# Claremont Business Park 2 Filing No. 1 ). 3

## STREET IMPROVEMENT PLANS (INCLUDING STORM SEWER)

STREET IMPROVEMENT PLANS	
PROJECT NO. 44-037	DATE: 04/28/2020
DESIGNED BY: GW	HORIZONTAL: N/A
DRAWN BY: CLP	VERTICAL: N/A
CHECKED BY: VAS	SHEET 1 OF 12
S101

File: Q:\44037A-CBP F2-Lots 1-8\44037A-CBP F2-Lots 1-8.dwg Const Dwg\STREET AND STORM\S03.dwg Plotstamp: 10/21/2020 10:58 AM

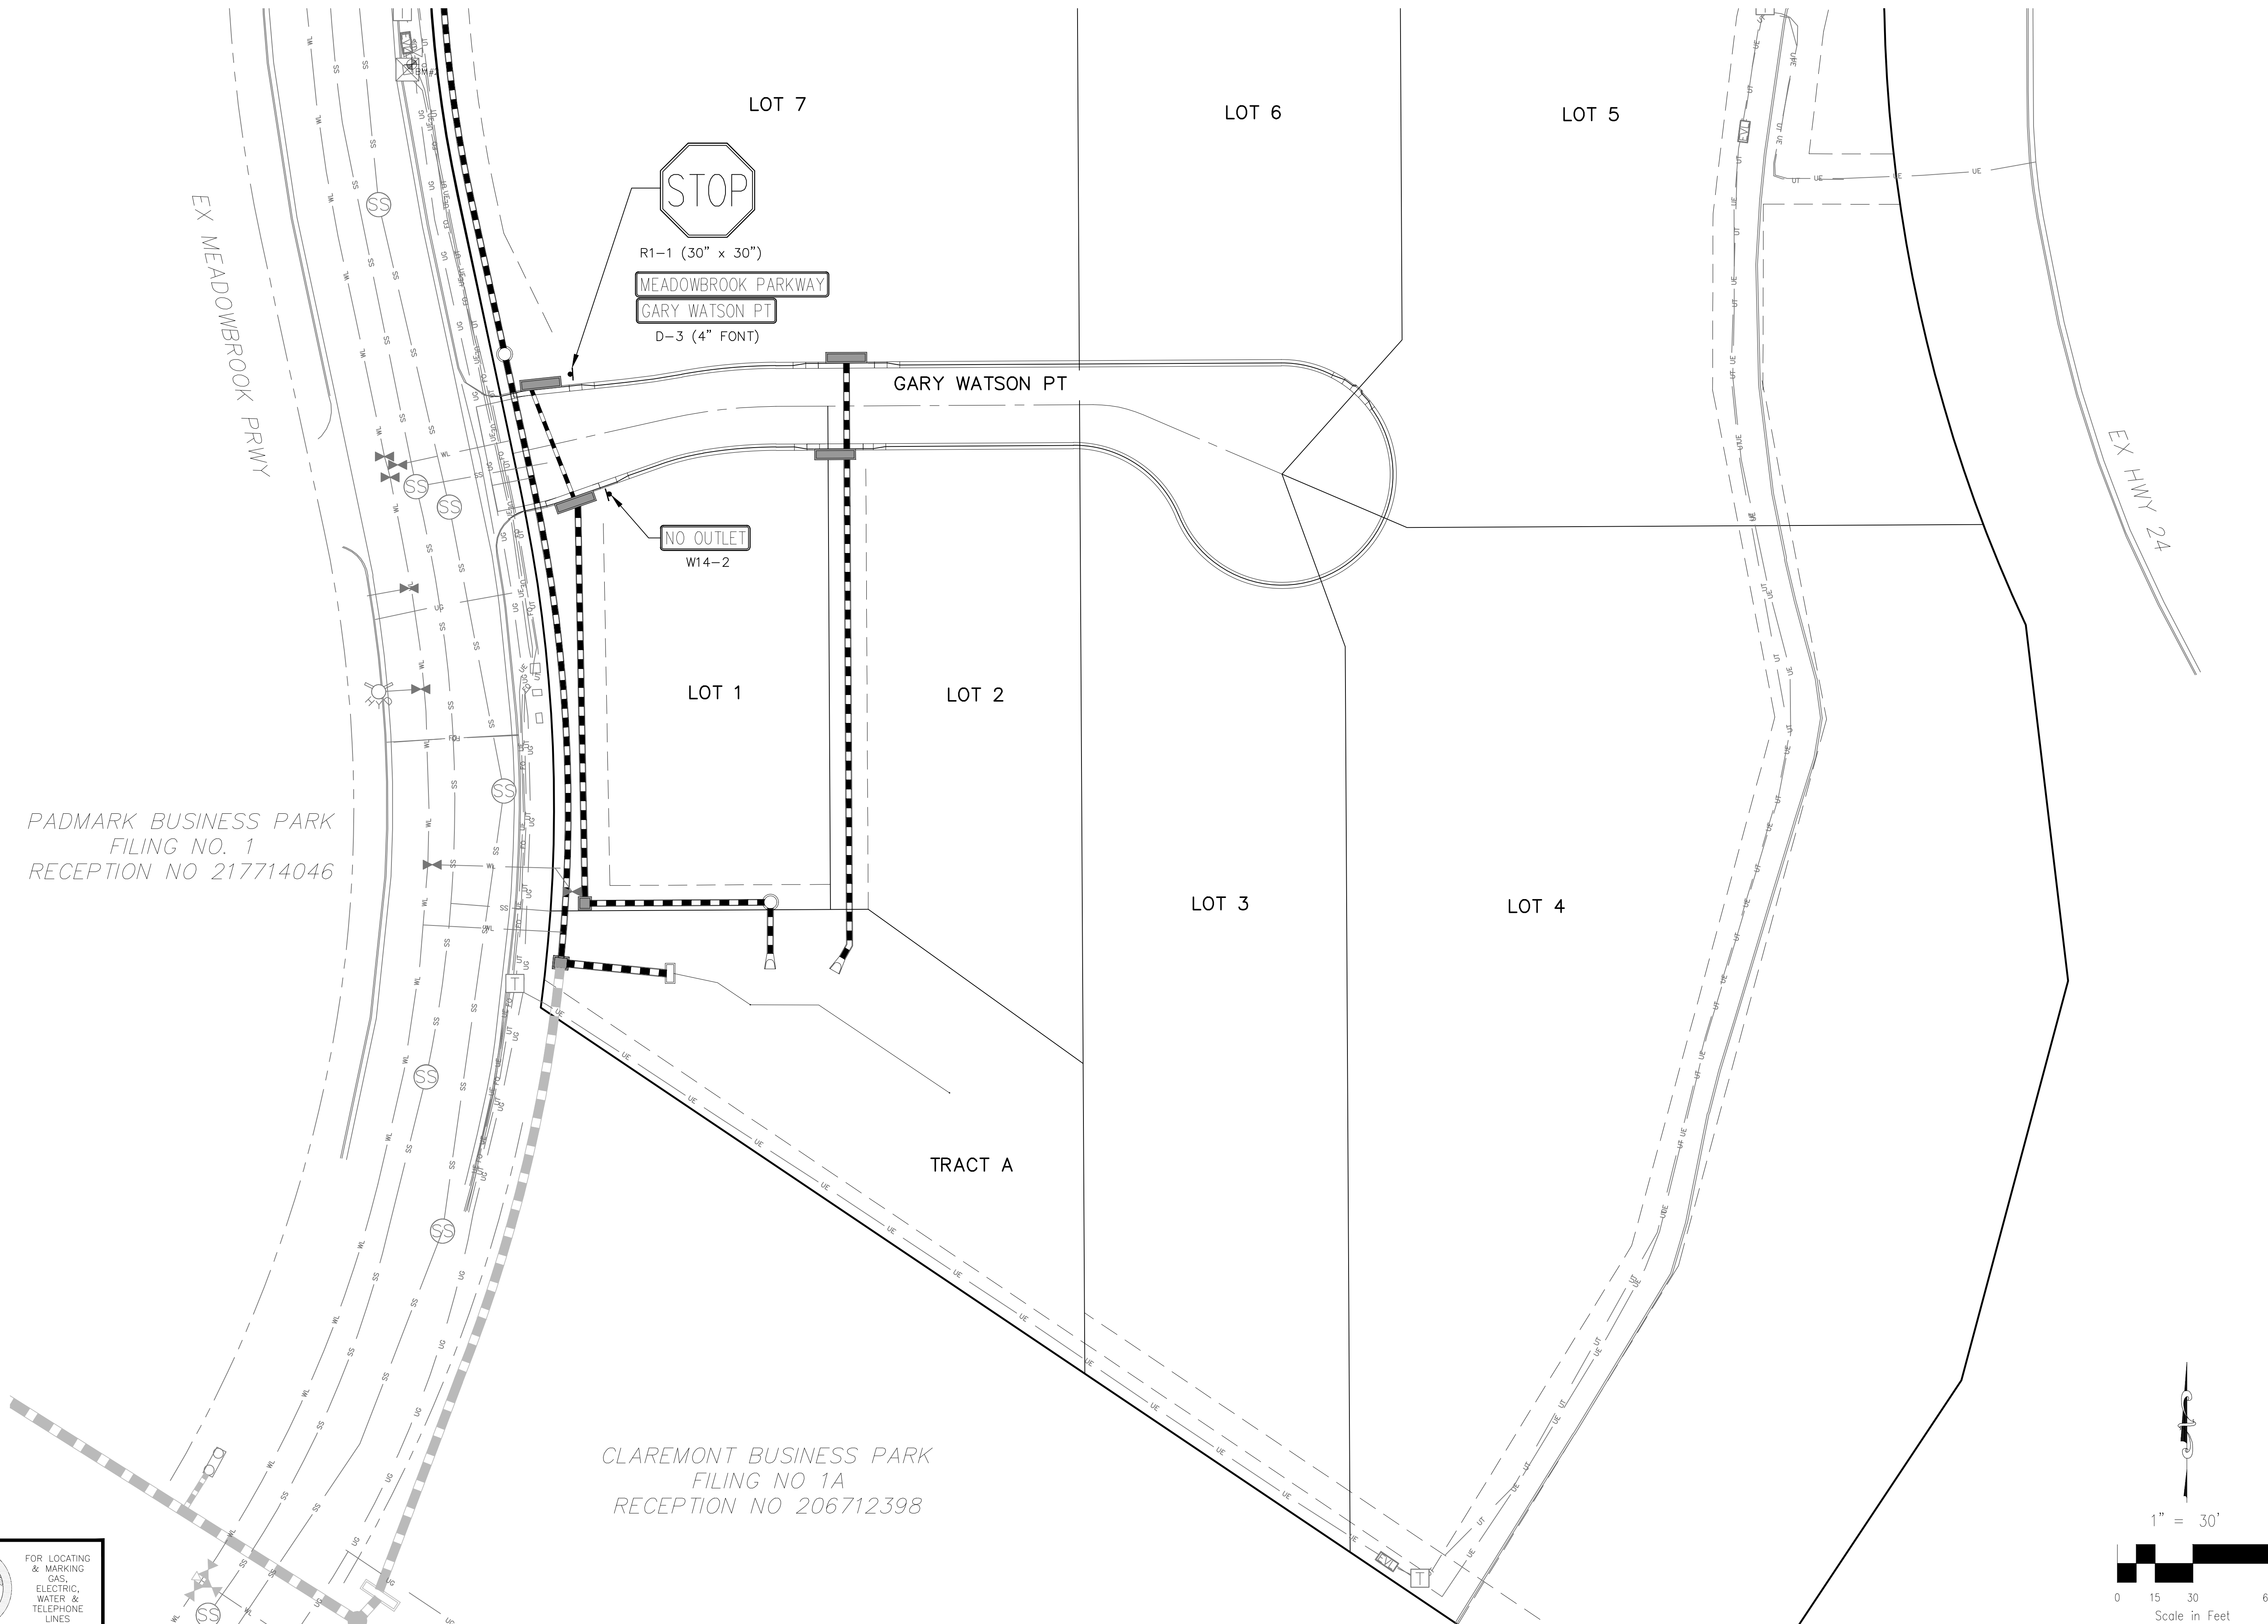
Please specify the appropriate county standard detail. Be aware that the BoCC recently approved changes to the ECM adding CH6 Accessibility which provides guidelines for Pedestrian facilities. Be sure to use the latest details.

DETAIL AND NOTE ADDED
